Date: November 28, 2022

Response to Comments

Project Name: James G, Murphy Auctioneers
 Project File Number: PA22037 - Technical Review 1
 Review Completion: November 1, 2022

**ADMINISTRATIVE SITE PLAN**

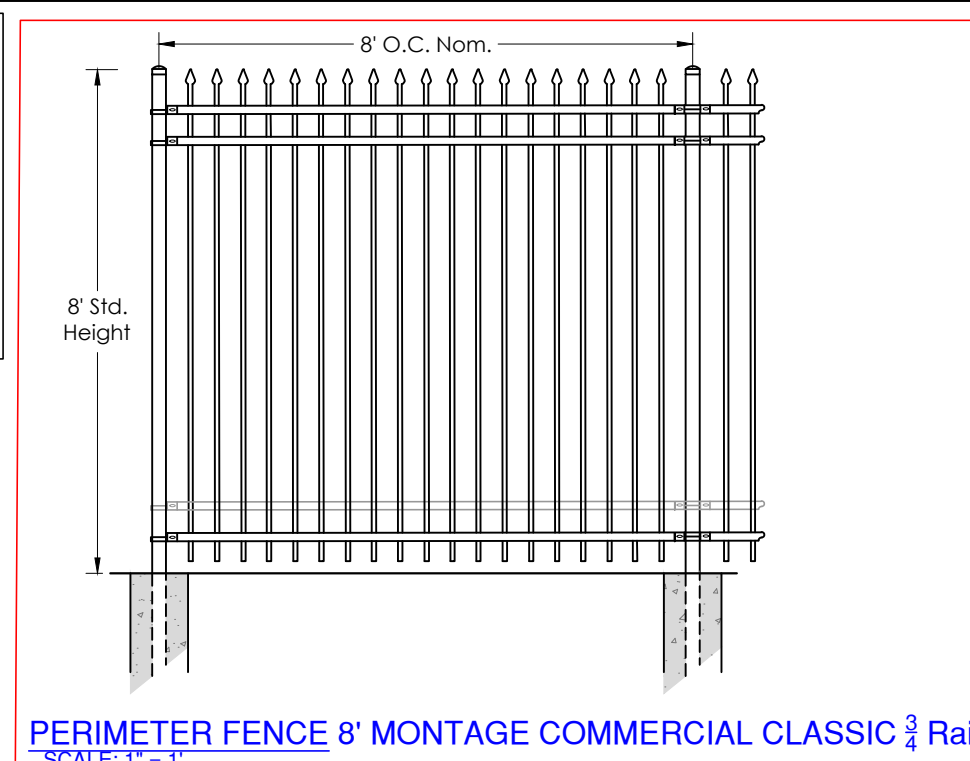
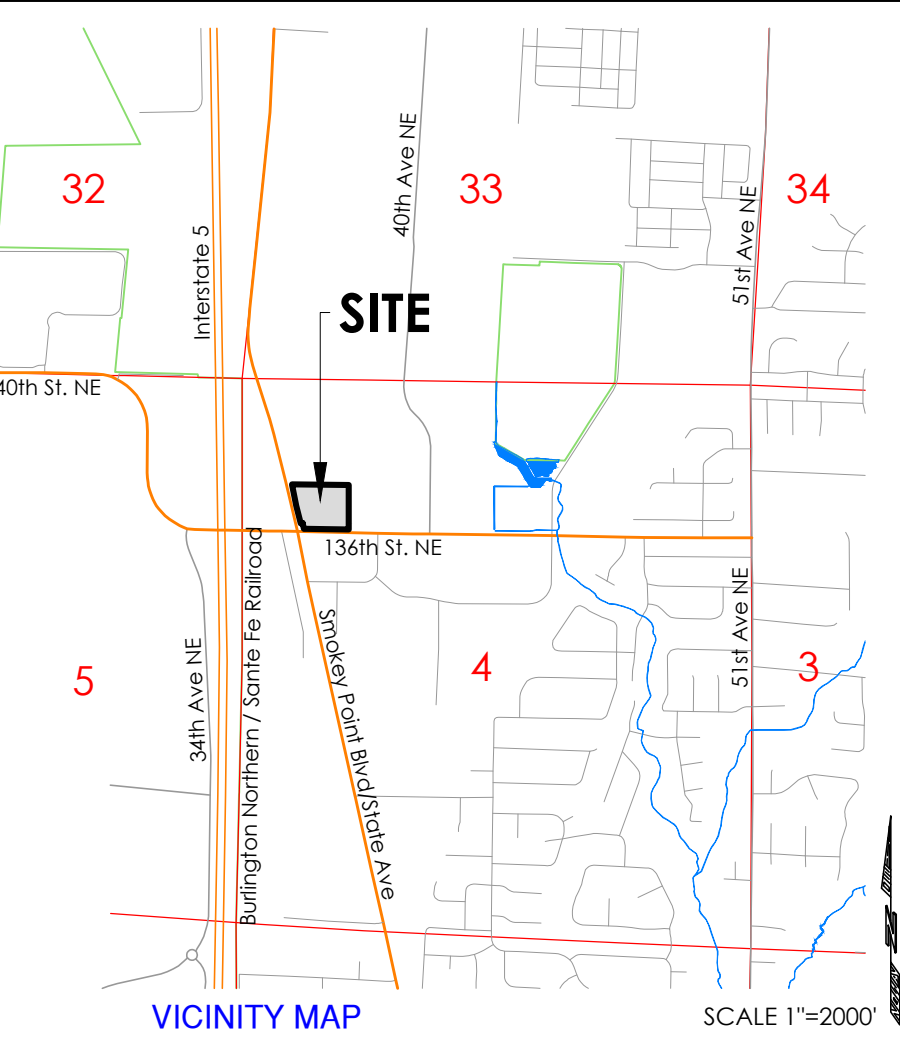
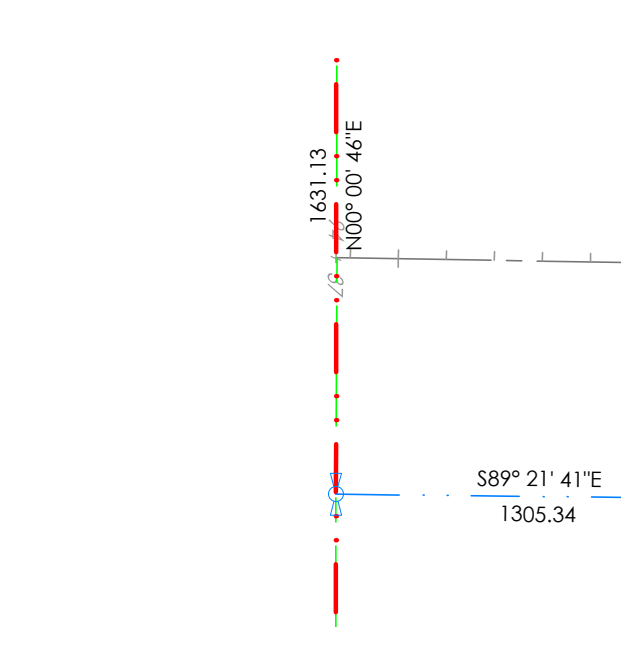
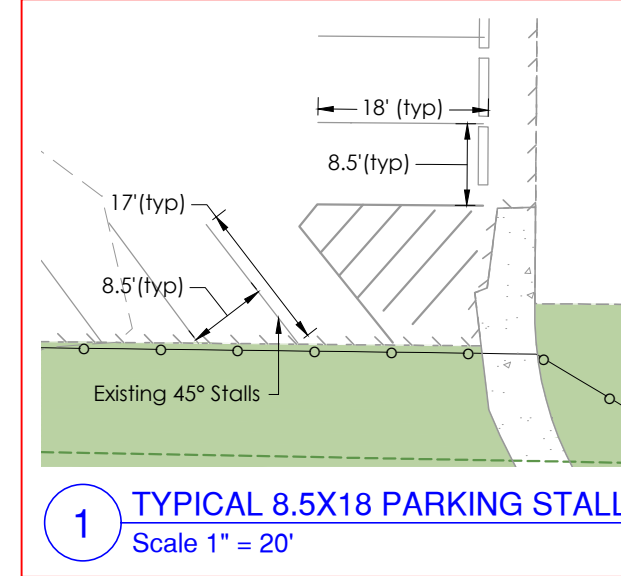
4. Sheet P1 shall be amended, as follows:

CITY COMMENTS	LAND TECH RESPONSE
<p>a. Include File No. PA22037 on all future plan submittals.</p> <p>b. Depict all encumbrances outlined in the Title Report prepared by Chicago Title Insurance Co., dated September 28, 2022, including reference to the applicable Auditor's File Number (AFN). If the encumbrances cannot be depicted then they shall be referenced.</p> <p>c. Pursuant to MMC 22C.020.320, storage space shall be apportioned and located in collection points, and designed, as follows:</p> <p>Commercial:</p> <p>3 SF per every 1,000 SF of manufacturing GFA.</p> <p>Storage space may be allocated to a centralized collection point.</p> <p>Outdoor collection points shall not be located in any required setback areas.</p> <p>Collection points shall be located in a manner so that hauling trucks do not obstruct pedestrian or vehicle traffic on-site, or project into any public right-of-way.</p> <p>Access to collection points may be limited, except during regular business hours and/or specified collection hours.</p> <p>Generally:</p> <ul style="list-style-type: none"> . Dimensions of the collection points shall be of sufficient width and depth to enclose containers for recyclables. . Architectural design of any structure enclosing an outdoor collection point or any building primarily used to contain a 	<p>a. PA 22-037 now included on all sheets.</p> <p>b. Encumbrances and reference to each is supplied on the administrative site plan, P1. These encumbrances are also listed on sheet C4.</p> <p>c. Again, trash/recycling area is provided and shown. Concrete Pad is described with concrete walls for screening</p> <p>There is no manufacturing space.</p> <p>The collection point along the center of the north property line is provided in compliance with MMC 22C.020.320</p> <p>As is.</p> <p>Aisles for access will be left unobstructed. Location has been accepted by Sanitation</p> <p>Access will be generally open and accessible</p> <p>The proposed collection point is 20' wide and 12' deep.</p> <p>The enclosure proposed is a Cinder Block Wall</p>

10/4/2022 1:52 PM  
Z:\Murphy, James G.\136th and Smokey Pnt Blvd\Sheets\C1 Civil Site Plan.dwg

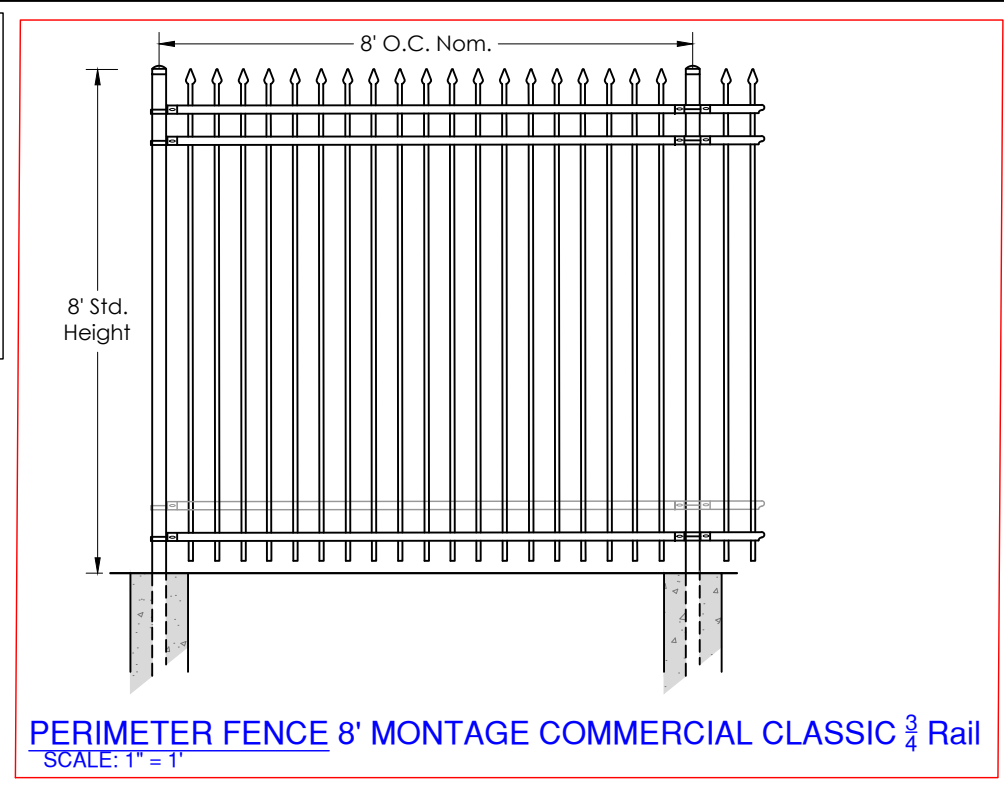
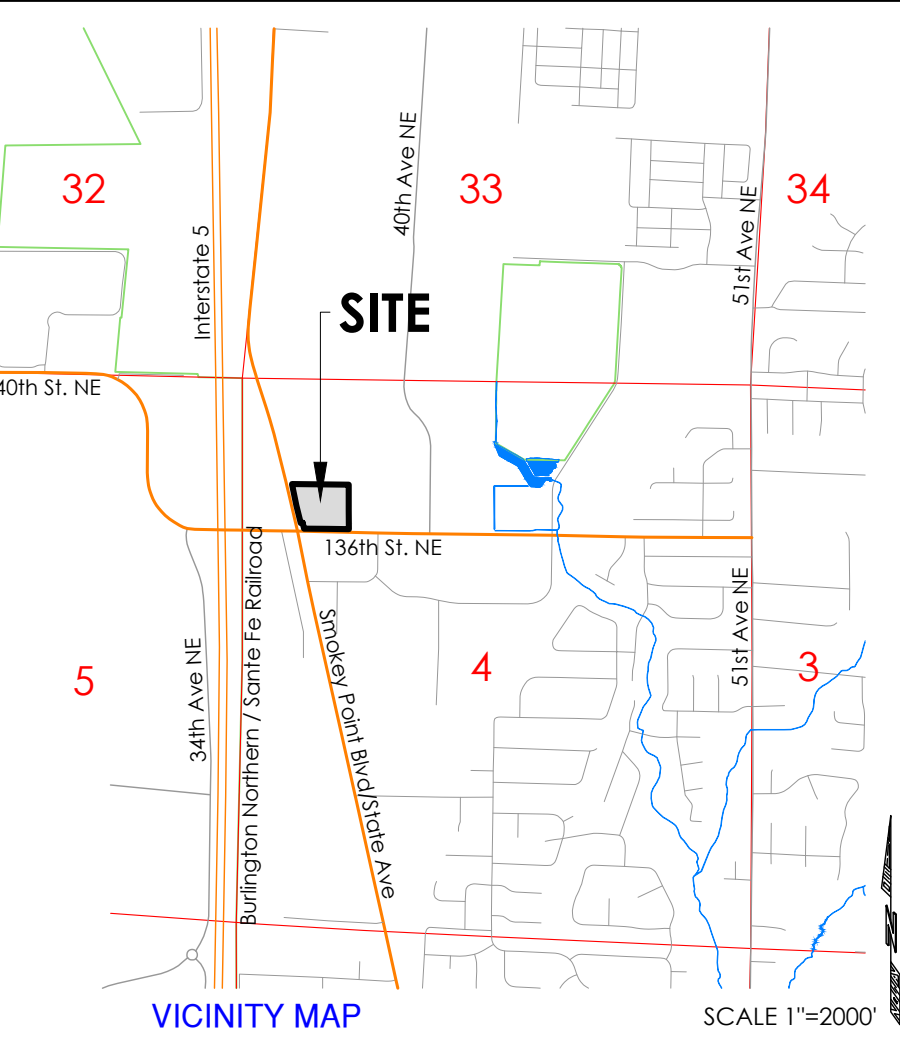
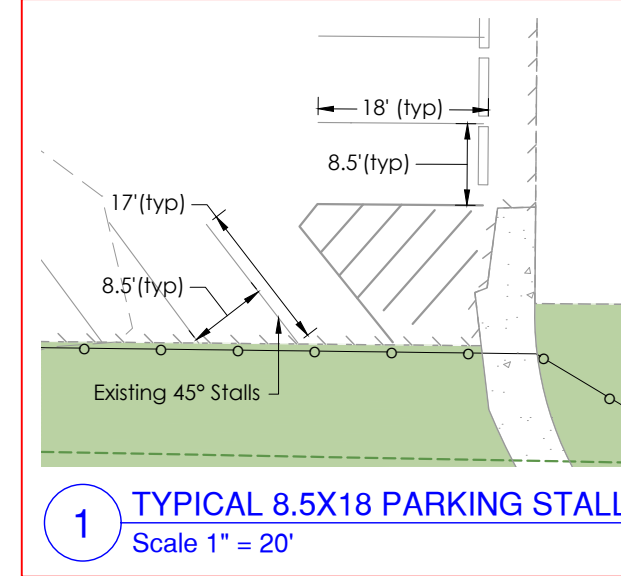
<p>2. A Traffic Impact Analysis (TIA) will be required. a. TIA is acceptable</p>	<p>Thank you.</p>
<p>Public Works: Reviewer: Kacey Simon, Civil Plan Review</p>	
<p>Stormwater Covenant and Easement form is attached.</p>	<p>Thank you.</p>
<p>PLANSET COMMENTS</p>	
<p>Sheet C1</p>	
<p>Drainage Report Comments:</p> <ul style="list-style-type: none"> • Please include a basin map on next submittal to identify facilities and basins used. • Total acres accounted for does not add 	<p>Basin map has been added to the drainage report WWHM section and referenced. The basin maps in the central portion of the 'West' and 'East' sides are modeled to overlap as a precaution to ensure either 'central' cell can</p>

CITY COMMENTS	LAND TECH RESPONSE
<p>up</p> <ul style="list-style-type: none"> I'm having a hard time following your WWHM report. I could not replicate what you created so please include the whole report on next submittal 	<p>accommodate the small space behind the building. (The contractor had an idea to direct water in this rear area behind building to the cells. The modeling with these overlapping areas will allow any as-built condition to be accommodated)</p> <p>The mitigated areas in the WWHM exceed the 4.58-acres of conversion. There are multiple Land-Use elements distributed through the report. Adding each up results in the total pre-developed area. Further, when Bioretention cells are used, the areas of the cells themselves shall be discounted from the overall basin modeling. On this system, we are not accounting for this as a conservative measure in an effort to get approvals.</p> <p>WSDOT Precipitation Series is used. WWHM report is attached to Drainage Report. WWHM PDF Report is also provided.</p>

SHEET  
C4  
of  
C9

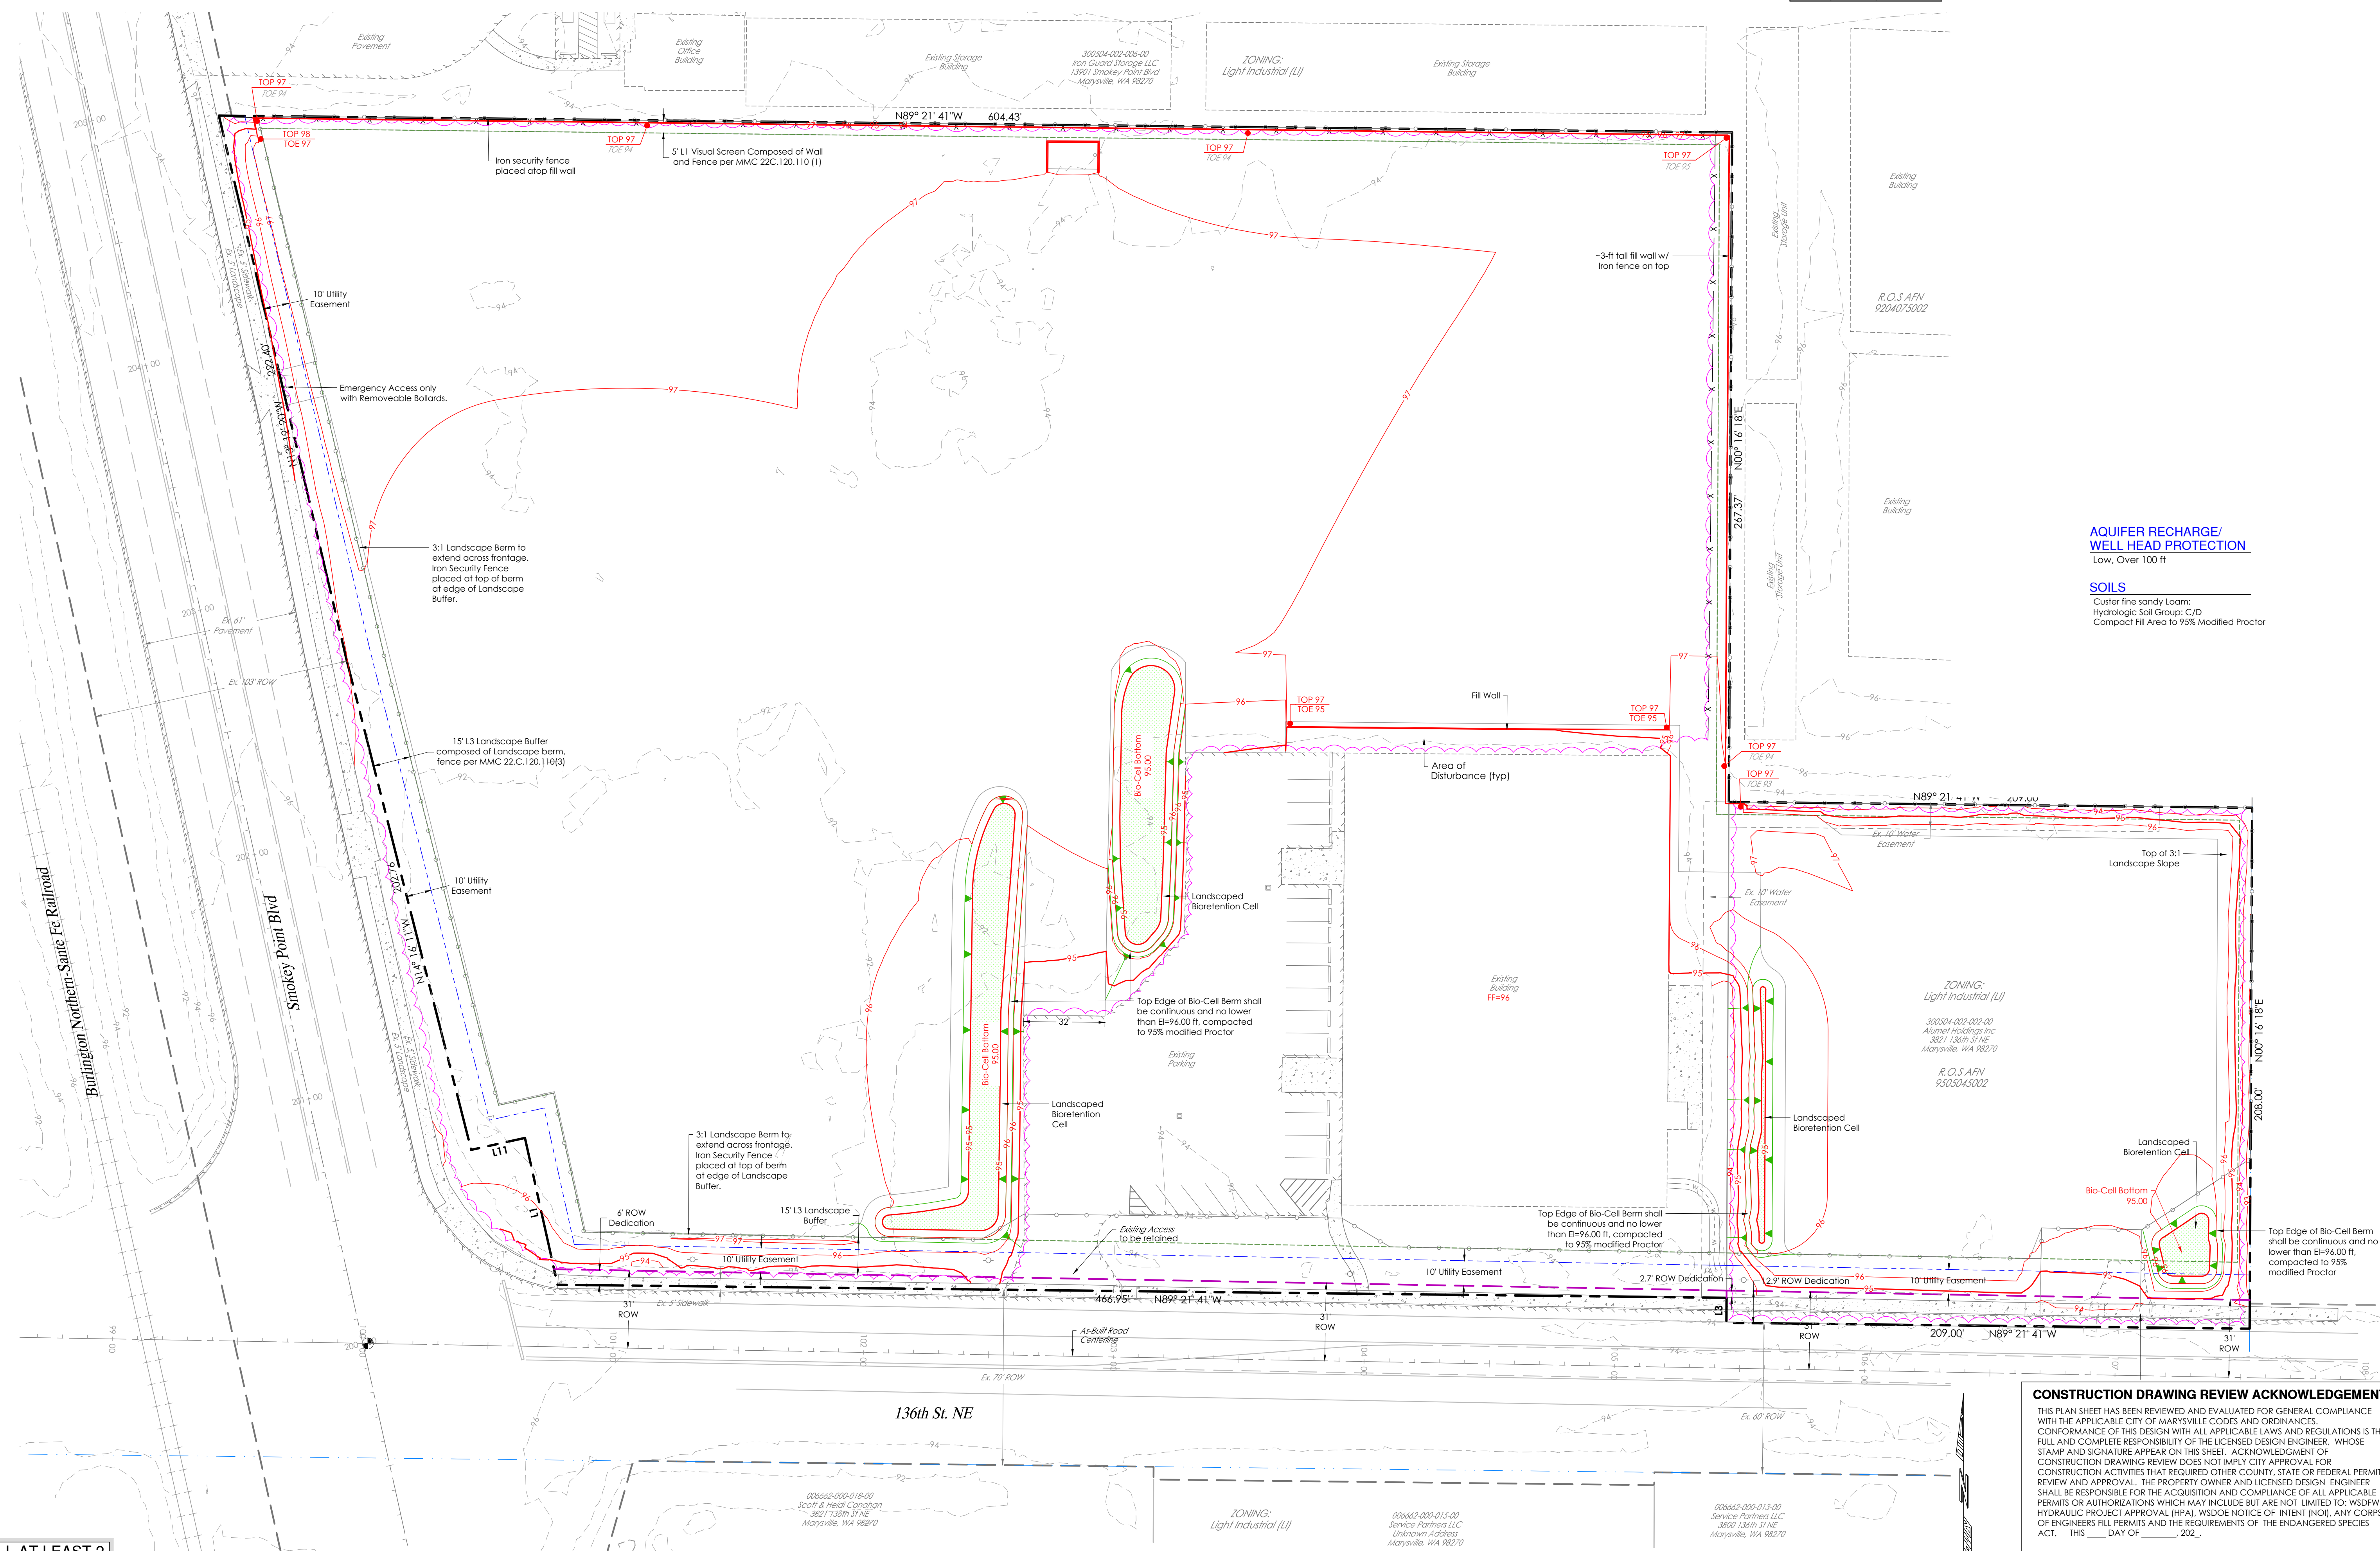
<p>Sheet C4</p>	
<p>This portion of the site will need to be paved.</p>	<p>Driveways and approaches will be paved. JG Murphy is cognizant of dust control and only uses clean gravel with 0% fines content. The gravel is 12" thick composed of multi-layers of varying gradations to prevent mud from pumping which would lead to tracking. There will be no mud track out or dust generated on this site.</p> <p>Asphalt ramps are proposed into the storage area of the site which will further prevent tracking of gravel onto city streets. No gravel access is adjacent to the City streets. All driveways and ramps are paved to city street exceeding 20-feet.</p> <p>The storage areas through the bulk of the site will cannot be paved. There is no ability to predict what equipment, material, machinery, or liquidated inventory that may be stored on site at any one time. Any of the items stored, except for passenger vehicles would damage asphalt paving. The site would be broken asphalt in a matter of months. <u>Gravel is required for the operations at this site.</u></p> <p>Meeting with Ken and Chris on 12/8/2022 gave acceptance of a Conditional gravel of the site, provided no gravel is tracked offsite, and no dust</p>

CITY COMMENTS	LAND TECH RESPONSE
	is generated.
This portion may remain gravel for parking of tracked equipment	Please see above.
Sheet C8	
Please add several spot elevations and coordinates to the plans.	Spot elevations with coordinates will be added to the plan although the site is already grade to final specifications 😊
These base lines are not clear to show the contractor how to properly grade the site	<p>The contractor did a fairly good job building the subgrade using a digital elevation model and 3D grade control of the design surface that we gave them. The grade control equipment integrated into bulldozers and excavators give precise feedback to the operators directly related to our 3D design surface model in real-time as they are moving through the site. Link to a Trimble Youtube.</p> <p>https://play.vidyard.com/q9mq5kW1ZLhASSvEqpA7VM.jpg</p> <p>The surface was surveyed and reviewed by our team for verification prior to importing rock to ensure the grade slopes to each zone (basin) as required. The edge along Smokey Point Blvd and 136th for the western portion of the site was a little low and we did request an additional compacted 6" lift at the perimeter and through the ridge separating the "West" from the "West Central" areas. This survey may be supplied for as-built close-out but was required by us to ensure consistency in design. This grade control has not been confirmed for the east side of the site, or adjacent to the building to the north. (Hence the dual wwhm areas overlapping in prior response)</p> <p>A 50-ft offset has been added to this plan for fulfillment of request. As-builts will denote the finished survey grade.</p>
